## DEPARTMENT OF PUBLIC WORKS

### MEMORANDUM

**TO:** All Staff  
**FROM:** Public Works Plan Review Team  
**DATE:** June 5<sup>th</sup>, 2023  
**SUBJECT:** SP-23-00002 Mills-2

JOB NO.	1223
DATE	5/1/23
SHEET	1
OF	2
DRAWN BY	MARK AND AMY MILLS
CHECKED BY	MARK AND AMY MILLS
DATE	ELLENBURG, WASHINGTON
PROJECT	4440 W. DRY CREEK ROAD
DESCRIPTION	MIG Surveying
CONTACT	Combs, Washington 99023 (509) 846-0797

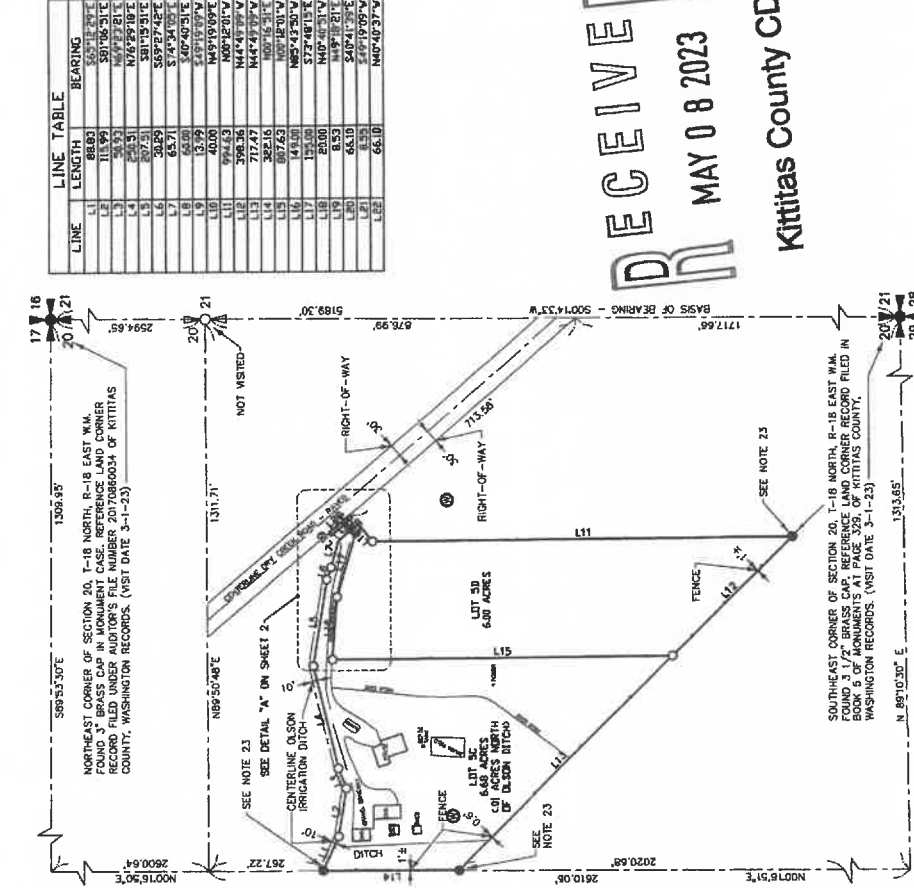
<b>SURVEY</b>	<p>The following elements will need to be addressed prior to final:</p> <ol style="list-style-type: none"> <li>1. Legibility of small text for the topo features on Lot 5C, Sheet 1. Please check minimum text height of 0.08".</li> <li>2. Legibility of line Tag labels on sheet 1 due to crossing linework and staged Tag Labels.</li> <li>3. Please identify Dry Creek Road as "County Right of Way".</li> <li>4. Legibility of "Gravel Driveway" text on Sheet 2 due to hatching.</li> <li>5. Please clearly identify the Hatched area on Sheet 2 as the Access Easement, and identify it as "Herein Created" or "Created by separate document". (JT)</li> </ol>
<b>TRANSPORTATION CONCURRENCY</b>	<p>No transportation concurrency application is required at this time. (KH)</p>
<b>FLOOD</b>	<p>Parcel # 960738 is not mapped within the special flood hazard area (100-year floodplain).</p>
<b>WATER MITIGATION/ METERING</b>	<p>For the proposed short plat, the applicant must provide legal water availability for all new uses on the proposed lots of this project, which can be provided through mitigation certificates. Prior to final plat approval and recording, the following conditions shall be met:</p> <p>In accordance with KCC Chapter 13.35.027, the applicant shall provide one of the following documents before final plat approval:</p> <ol style="list-style-type: none"> <li>1. A letter from a water purveyor stating that the purveyor has adequate water rights and will provide the necessary water for the new use;</li> <li>2. An adequate water right for the proposed new use; or</li> <li>3. A certificate of water budget neutrality from the Department of Ecology or other adequate interest in water rights from a water bank.</li> </ol> <p>All applicants for land divisions shall also submit information on "proximate parcels" held in "common ownership" as those terms are defined in WAC 173-539A-030 and otherwise demonstrate how the proposed new use will not violate RCW 90.44.050 as currently existing or hereafter amended.</p> <p>Failure to obtain mitigation before commencement of an activity requiring mitigation shall be a code violation subject to enforcement under Title 18 KCC.</p> <p><b>Final Plat Notes</b></p> <p>The following notes shall be placed on the face of the plat:</p> <p>C-1 "Metering is required for all new uses of domestic water for residential well connections and usage must be recorded in a manner consistent with Kittitas County Code Chapter 13.35.027 and Ecology regulations."</p>
